Recommendation Report for Planning Permission

REF NO: LU/285/18/PL

LOCATION: 2 Kestrel Way
Littlehampton
BN17 7RD

PROPOSAL: Division of house into two dwellings and replacement of conservatory with flat
roofed extension

DRAWING	SCALE
PROPOSED BLOCK PLAN	1/100
DATE: SEPTEMBER 2018	
DRAWN: T. Murray	
DRAWING: 18/49/5	REVISION:

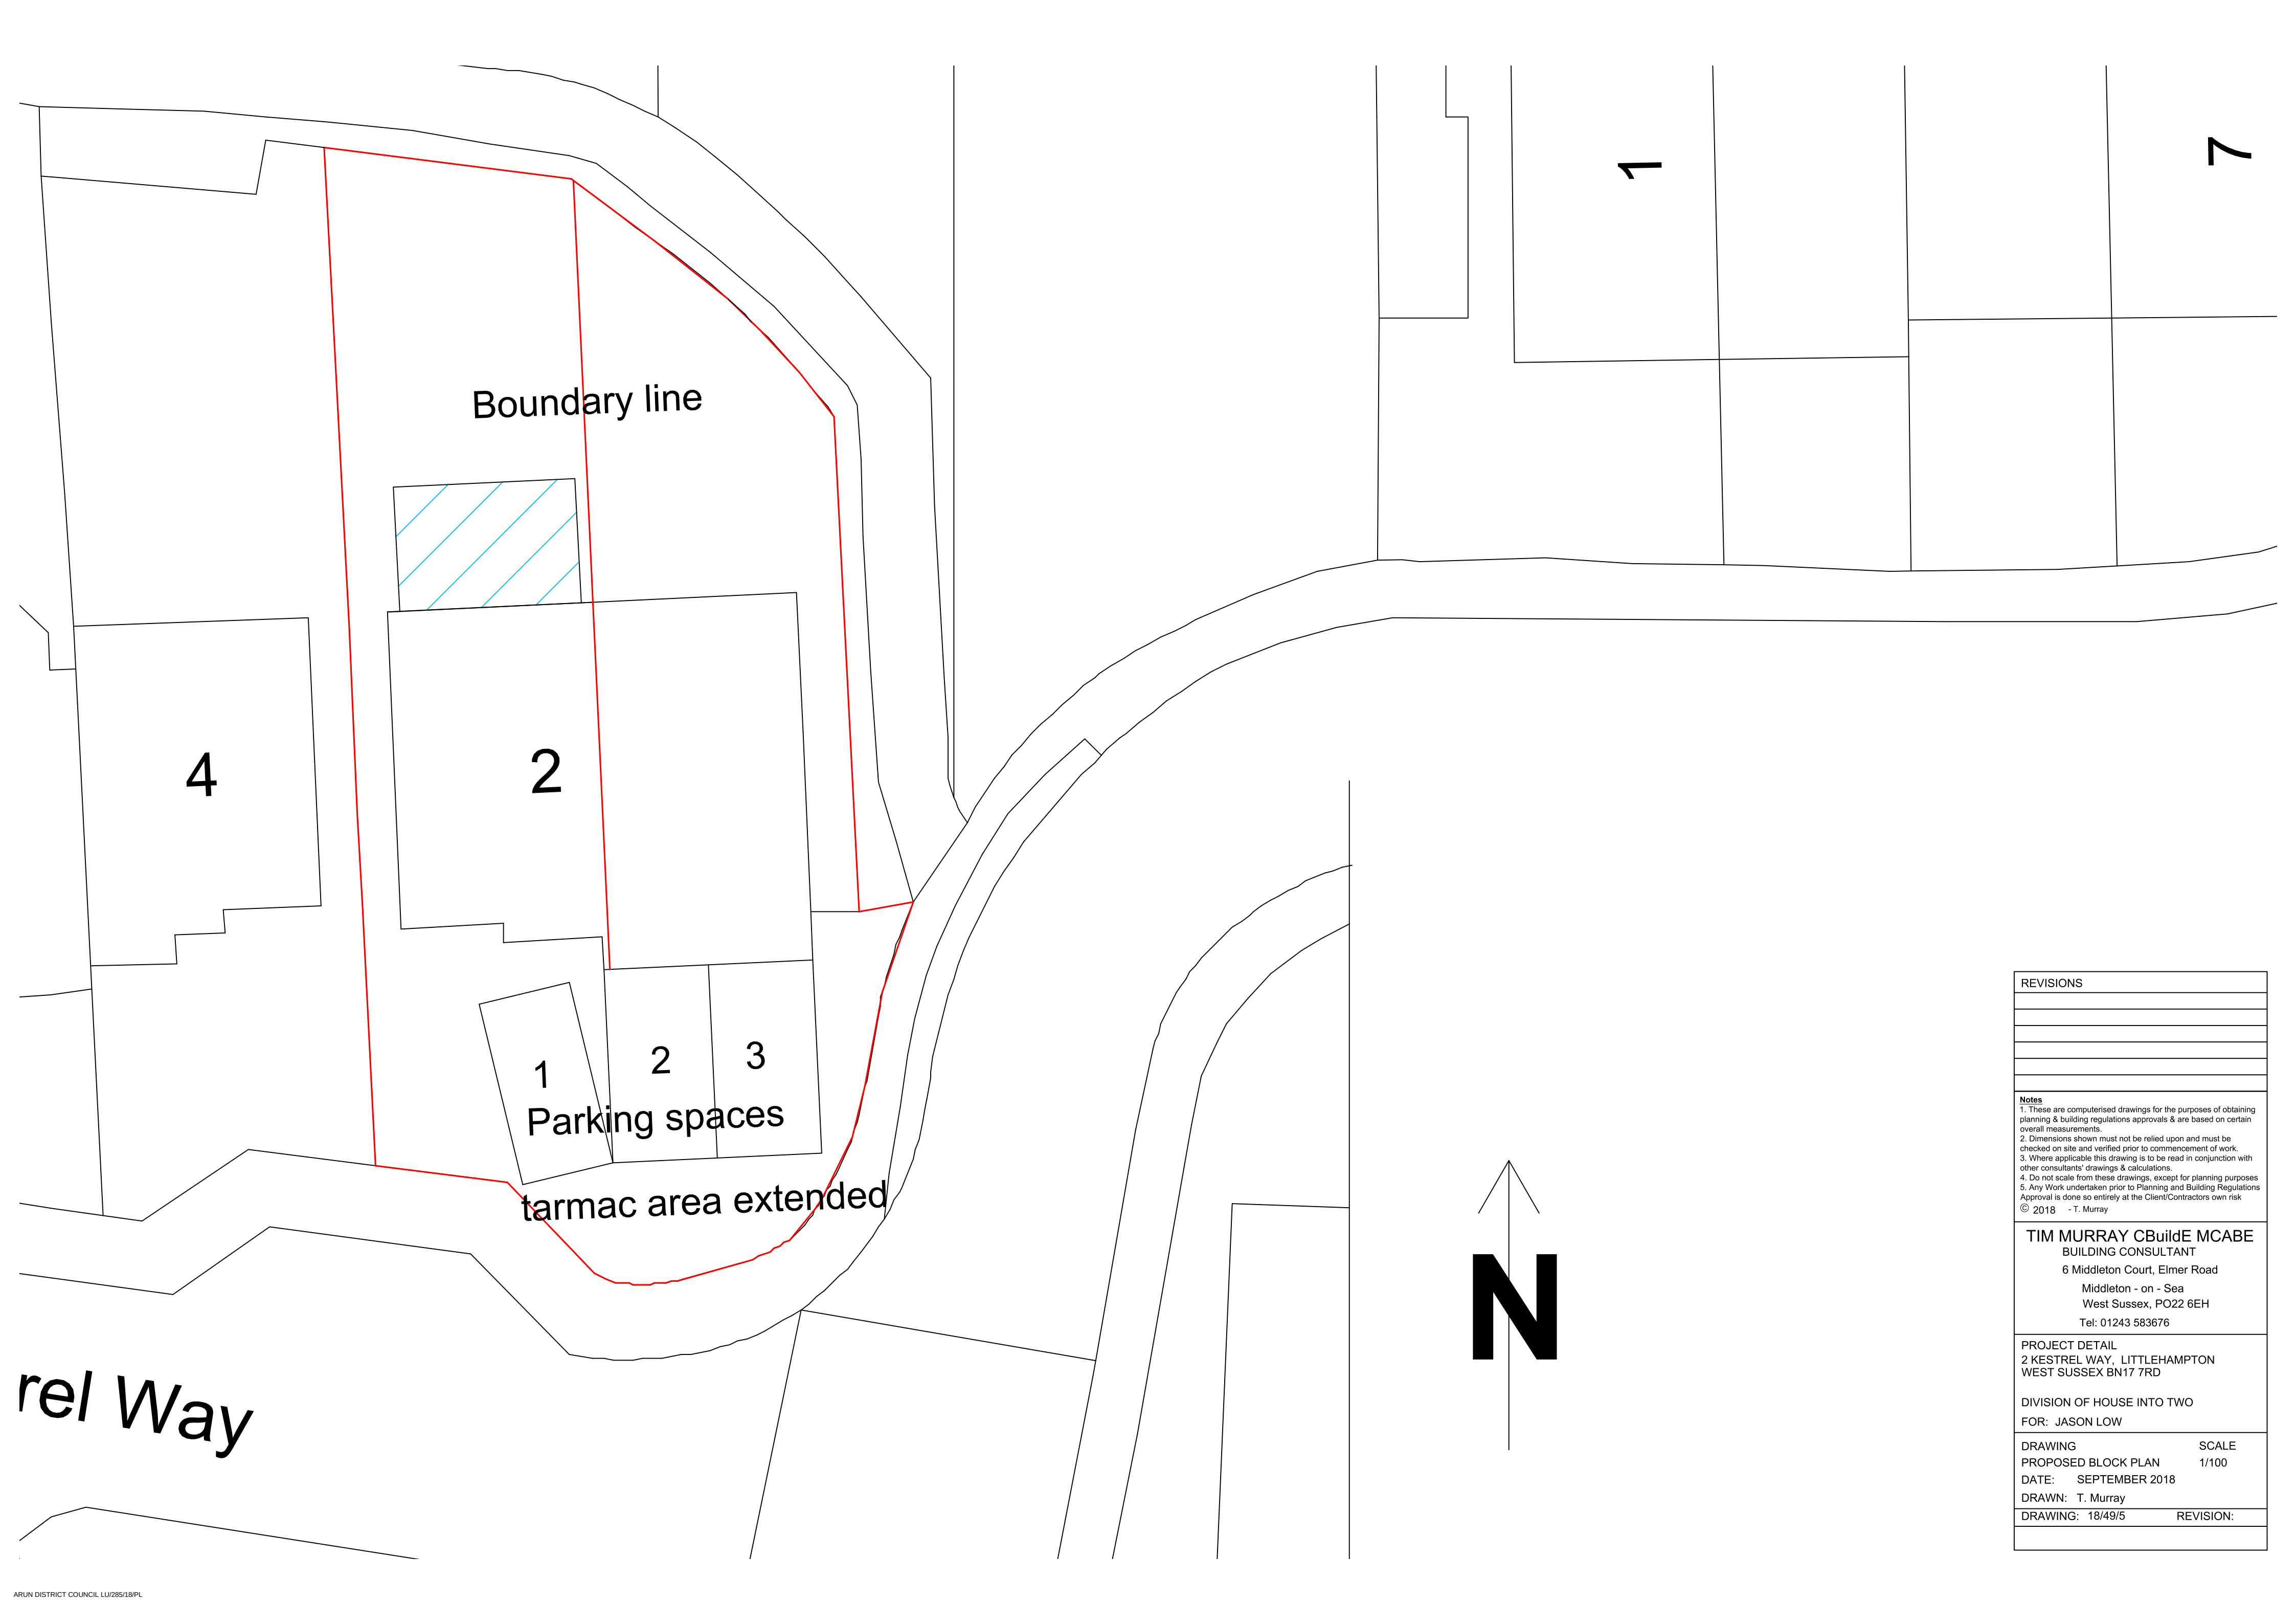
While the 3 spaces provided would be a shortfall of 1 space it was noted on the note that at the time of the site visit there were no on road parking restrictions along Kestrel way. Therefore, it is considered that the proposed parking arrangement would be acceptable.

From an assesment of the proposal it would result in the parking of 3 cars to the front of the dwelling. This would necessitate the extension of the existing tarmac area. Officers note that the application site is on the junction of Kestrel way and Seaton Park and that there is already parking spaces for 2-3 vehicles Off-road. Therefore it is considered that the proposed parking in the layout shown would not lead to any detrimental highway safety issues over the existing parking arrangement.

Reason: In the interests of amenity in accordance with policies D DM1 and D DM4 of the Arun Local Plan.
- 4 No part of the development shall be first occupied until the parking has been constructed in accordance with the approved site plan. These spaces shall thereafter be retained at all times for their designated purpose.

PROPOSED ROOF PLAN

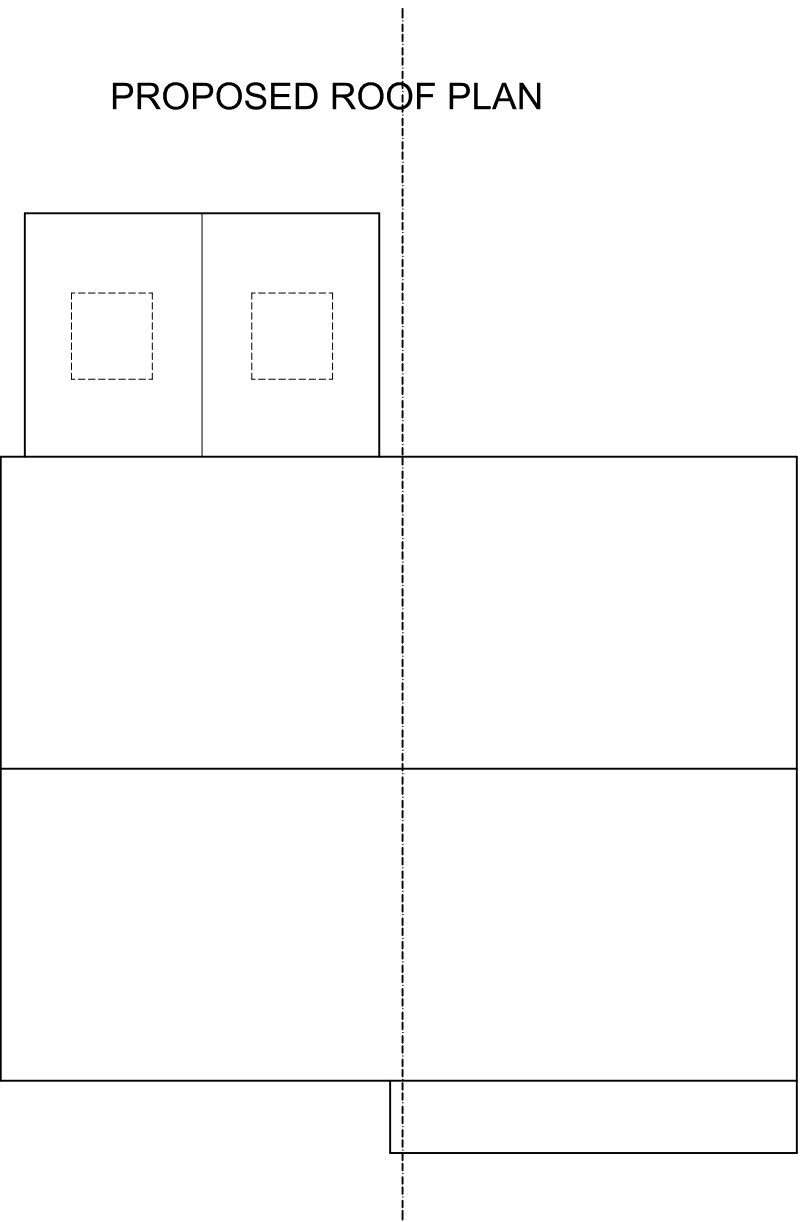
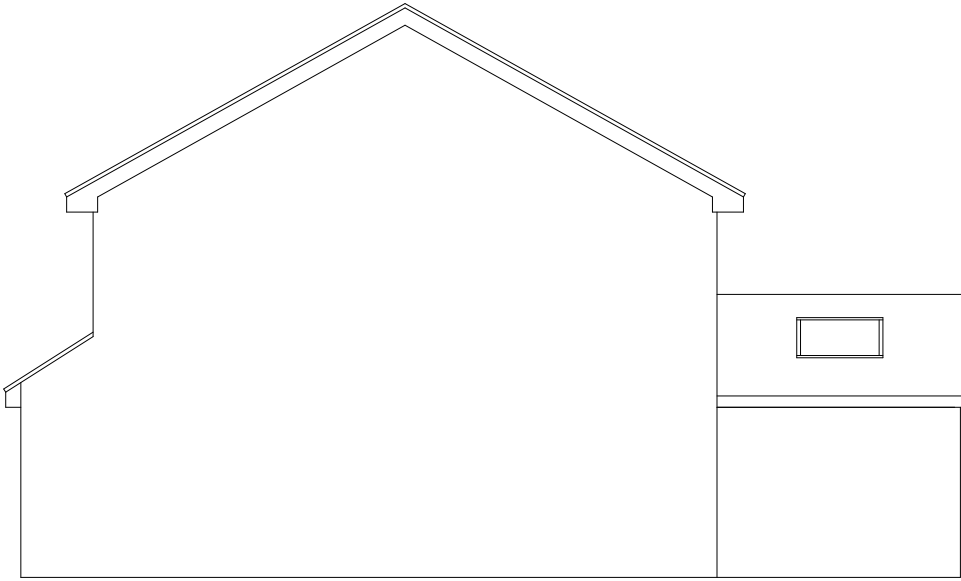
A single storey rear extension is proposed to the rear of the proposed semi-detached dwelling adjoining property number 4. The proposed rear extension would replace the existing conservatory. Having regard to the windows in the rear elevation of number 4 along with the separation distance and the orientation of the dwellings, it is considered that the proposals would not have detrimental impact on the occupiers of adjoining and neighbouring properties along with those to the rear. Some loss of light would occur to the kitchen/dining area of the adjoining new semi-detached property, as a result of the proposed rear extension. However, Officers note that there are both a set of French doors and a window in the rear elevation which would serve the kitchen/dining area. Therefore, Officers do not consider that any loss of light would be so detrimental as to warrant refusal, especially as when the 45 degree rule is applied, as the window would not be substantially affected.

PROPOSED GROUND FLOOR PLAN

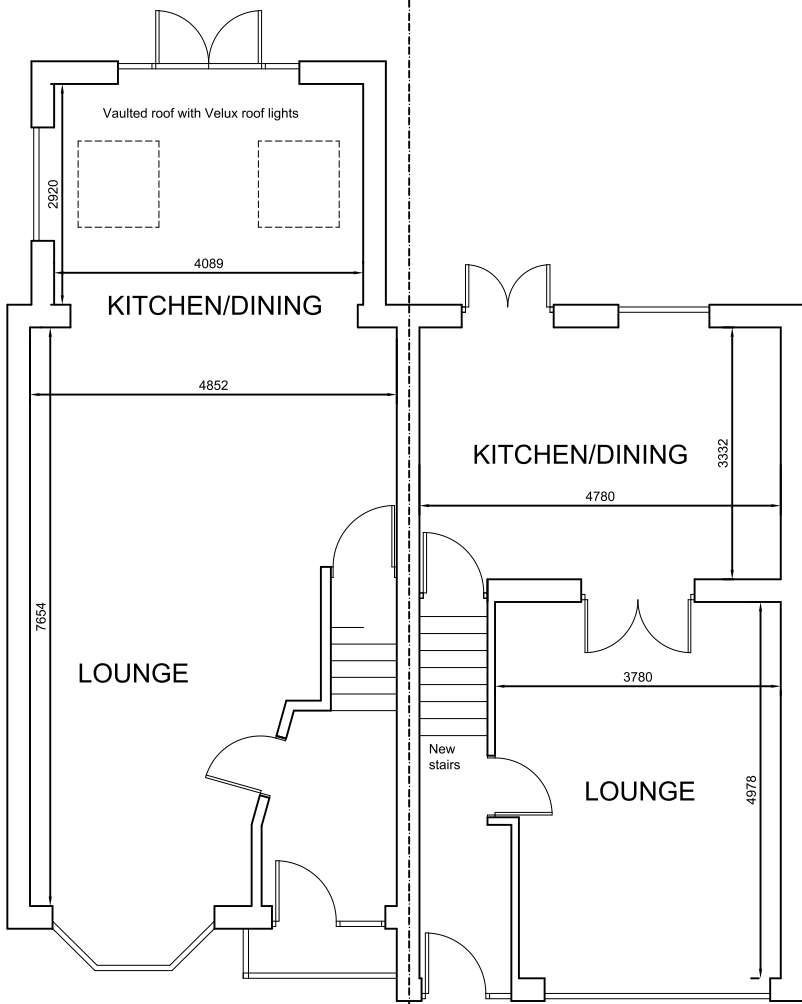
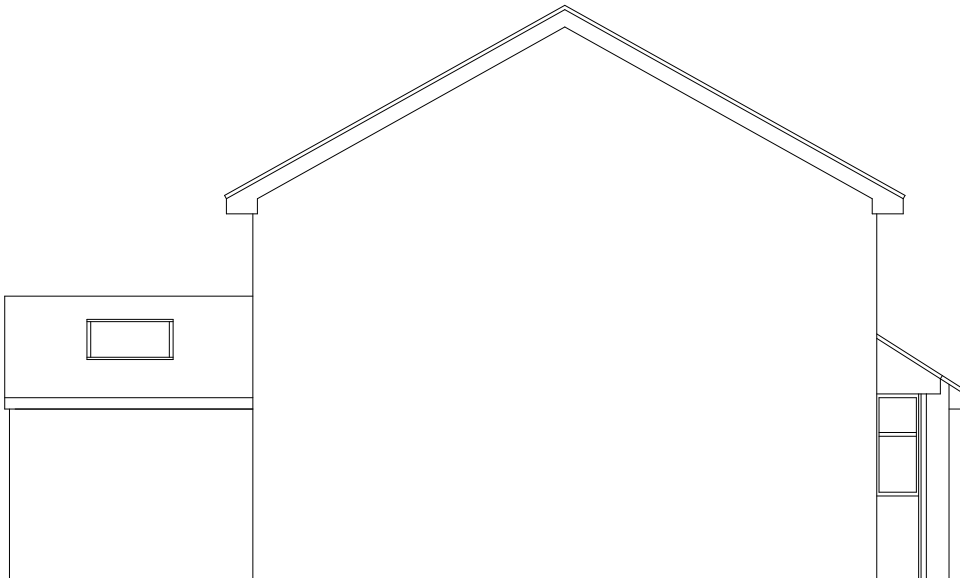
The applicant has not stated the number of bed spaces (persons) however from an assesment of the space standards the proposed dwelling furthest from adjoining property number 4 (henceforth known as dwelling 1) is considered to be a 2 bed property with 1 single bedroom and 1 double bedroom. Bedroom 3 as shown on the plan does not comply with the space standards for either a single or double bedroom. It is therefore considered that the dwelling would have 3 bed spaces (persons). For a 2 bedroomed, 3 person, 2 storey dwelling a minimum gross internal floor area of 70 metres squared is required. From an assesment of the submitted plans a gross internal floor area of approximately 76.7307 metres squared would be provided, which would comply with the Internal Space Standards. The dwelling adjoining property number 4 (henceforth known as dwelling 2) is considered, having regard to the internal space standards to be a 2 bed property with 2 single bedrooms. Bedroom 3 as shown on the plan does not comply with the space standards for either a single or double bedroom. It is therefore considered that the dwelling would have 2 bed paces (persons).

The Internal Space Standards do not take account of 2 storey, 2 bed, 2 person properties. Dwelling 2 would have a gross internal floor area of approximately 88.1419 metres squared which is considered to be acceptable. While the submitted plans do not show the provision of 2 .0 metres of internal storage per dwelling, as stated in the internal space standards, Policy D DM2 of the Arun Local Plan notes the Nationally Described Space standards to be guidance. Therefore, given the gross internal floor area that is proposed, Officers do not consider that the lack of provided internal storage space to be a reason for refusal.
